**From:** Plater, Roger - Communities  
**Sent:** 08 June 2021 10:25  
**To:** Michael Sackey  
**Cc:** DC Support Transport CDC Minor; Cllr Calum Miller  
**Subject:** 21-01304-F 16 Turnstone Green Bicester

<b>Planning application:</b>	21/01304/F
<b>Location:</b>	16 Turnstone Green Bicester OX26 6TT
<b>Description:</b>	Part garage conversion including internal alterations and replacement of some windows/doors.
<b>Type:</b>	Full Development
<b>Case Officer:</b>	Michael Sackey

Existing Plan

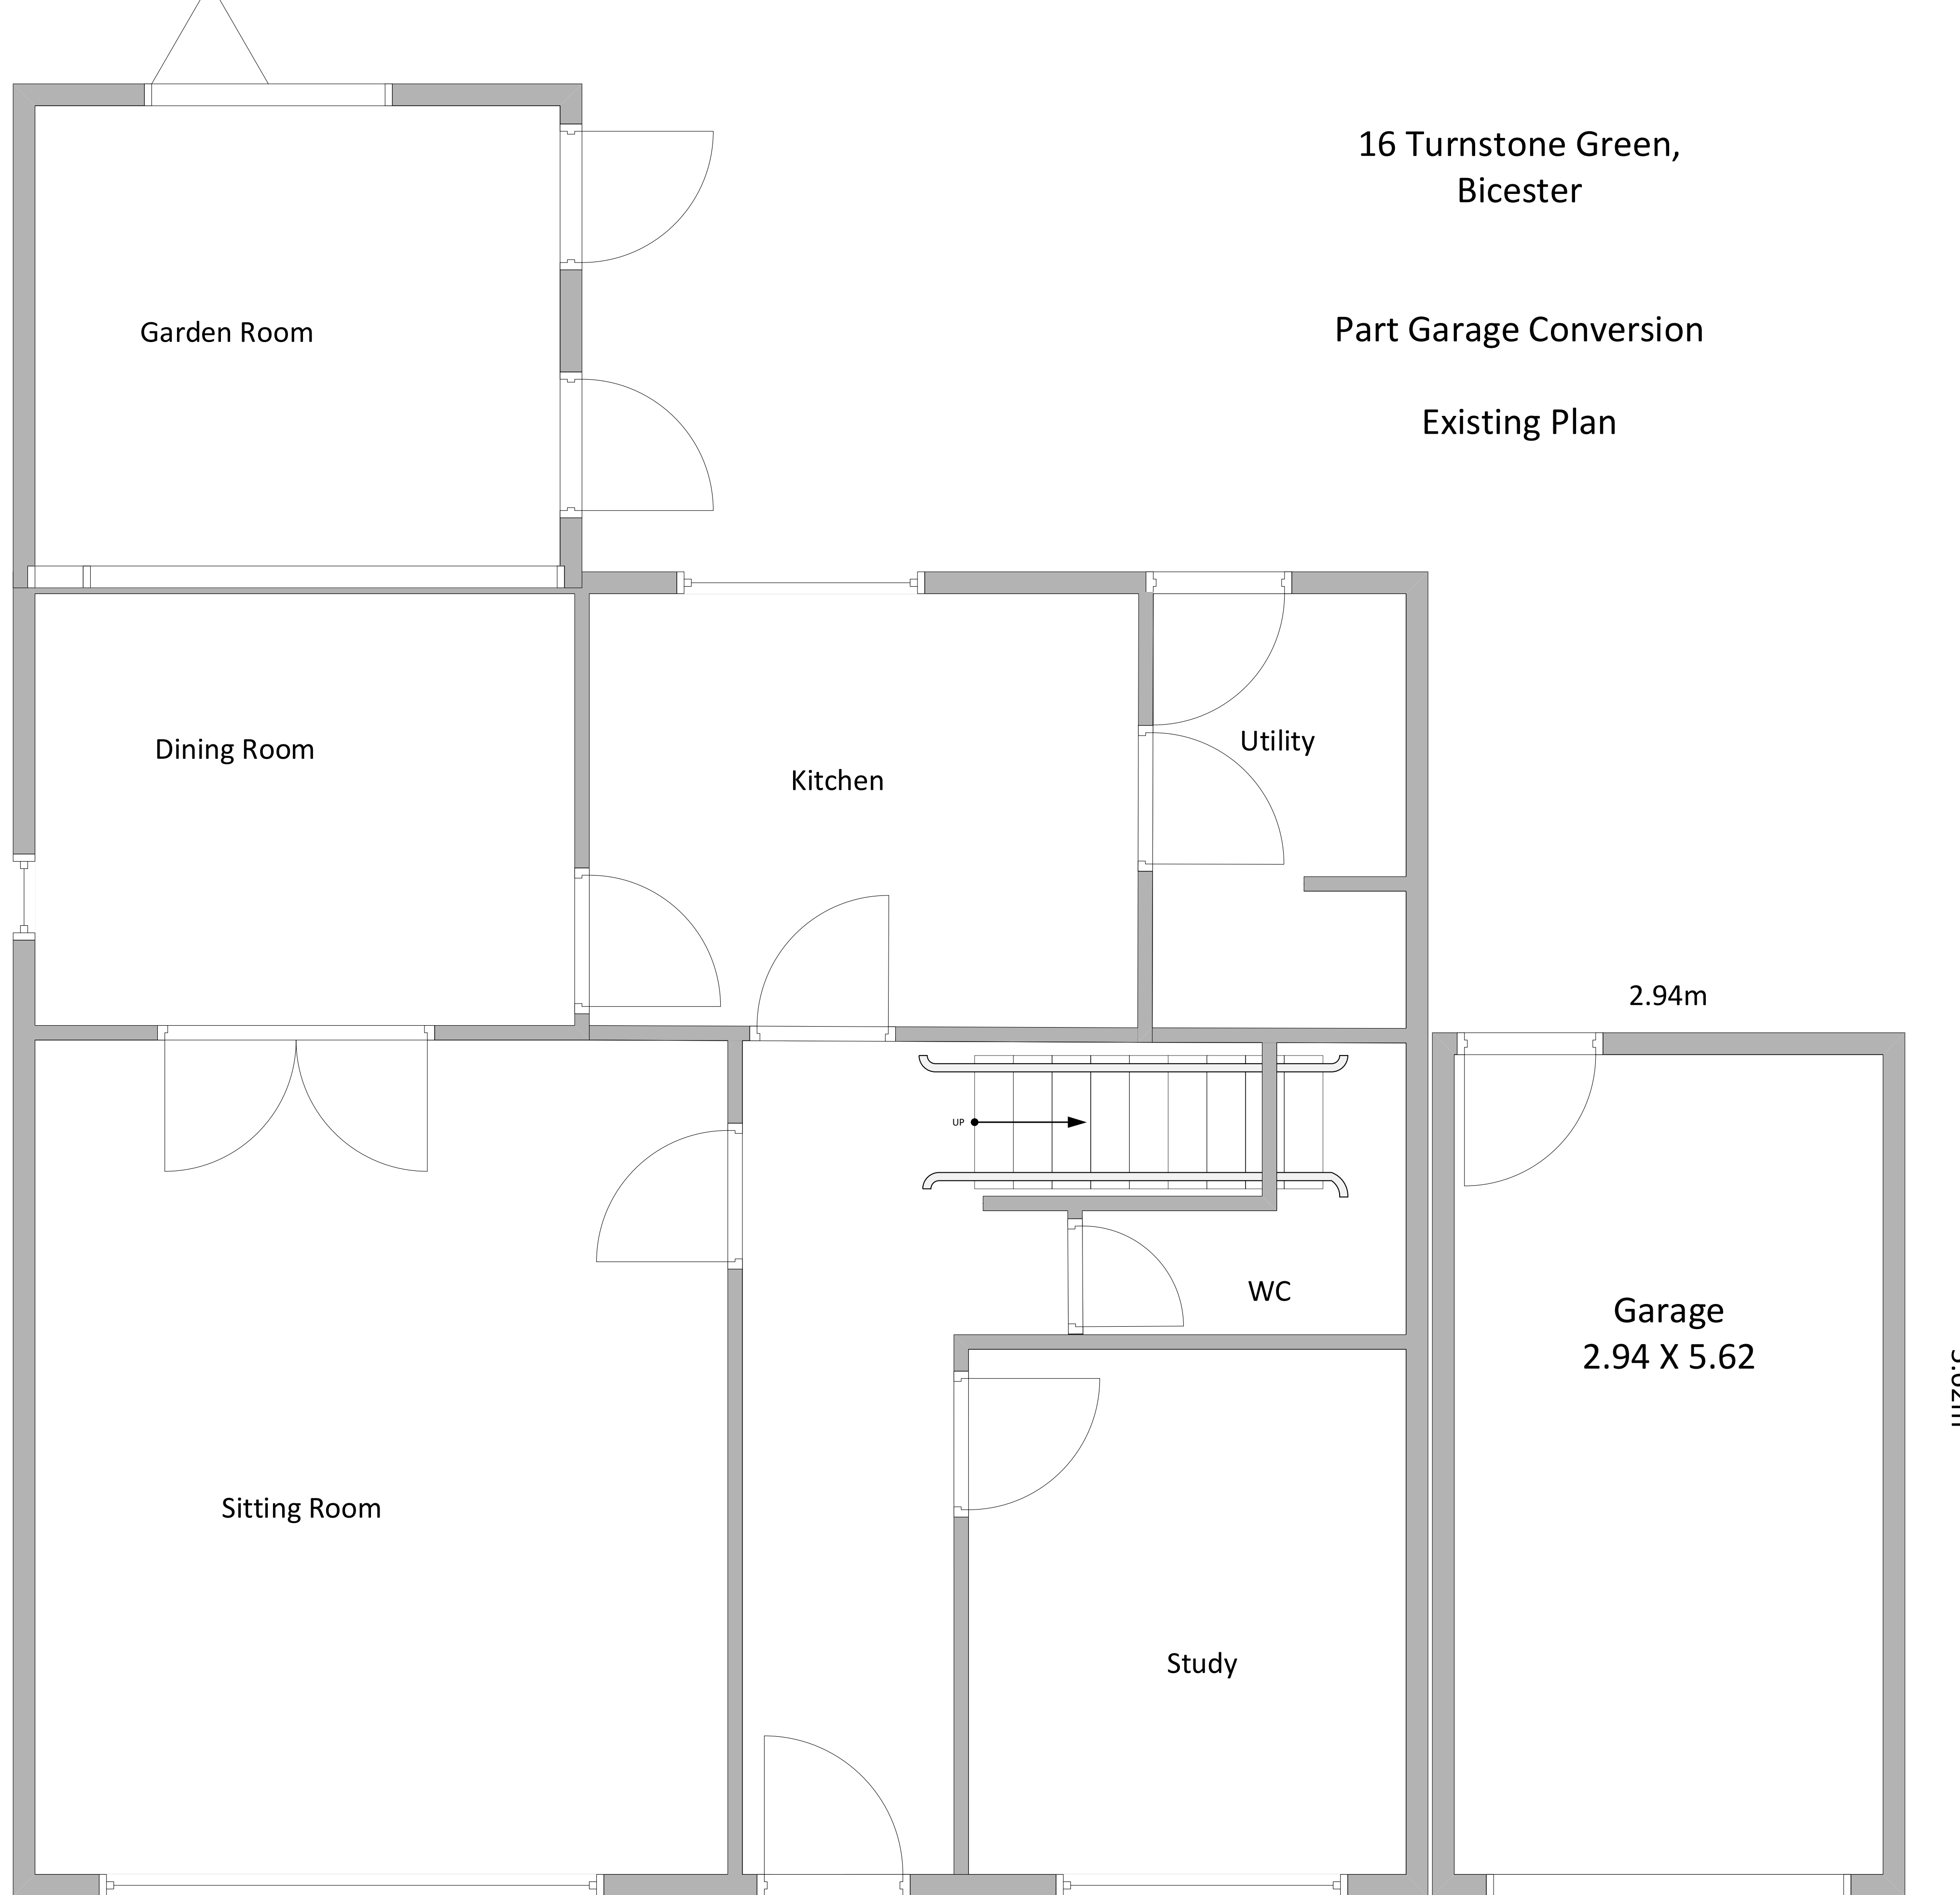
It would appear that there is adequate off-street parking available on the site, so that the loss of the garage is not significant. In any case, the dimensions of the existing garage are less than those specified in the Residential Roads Design Guide as required for it to be counted as a parking space.
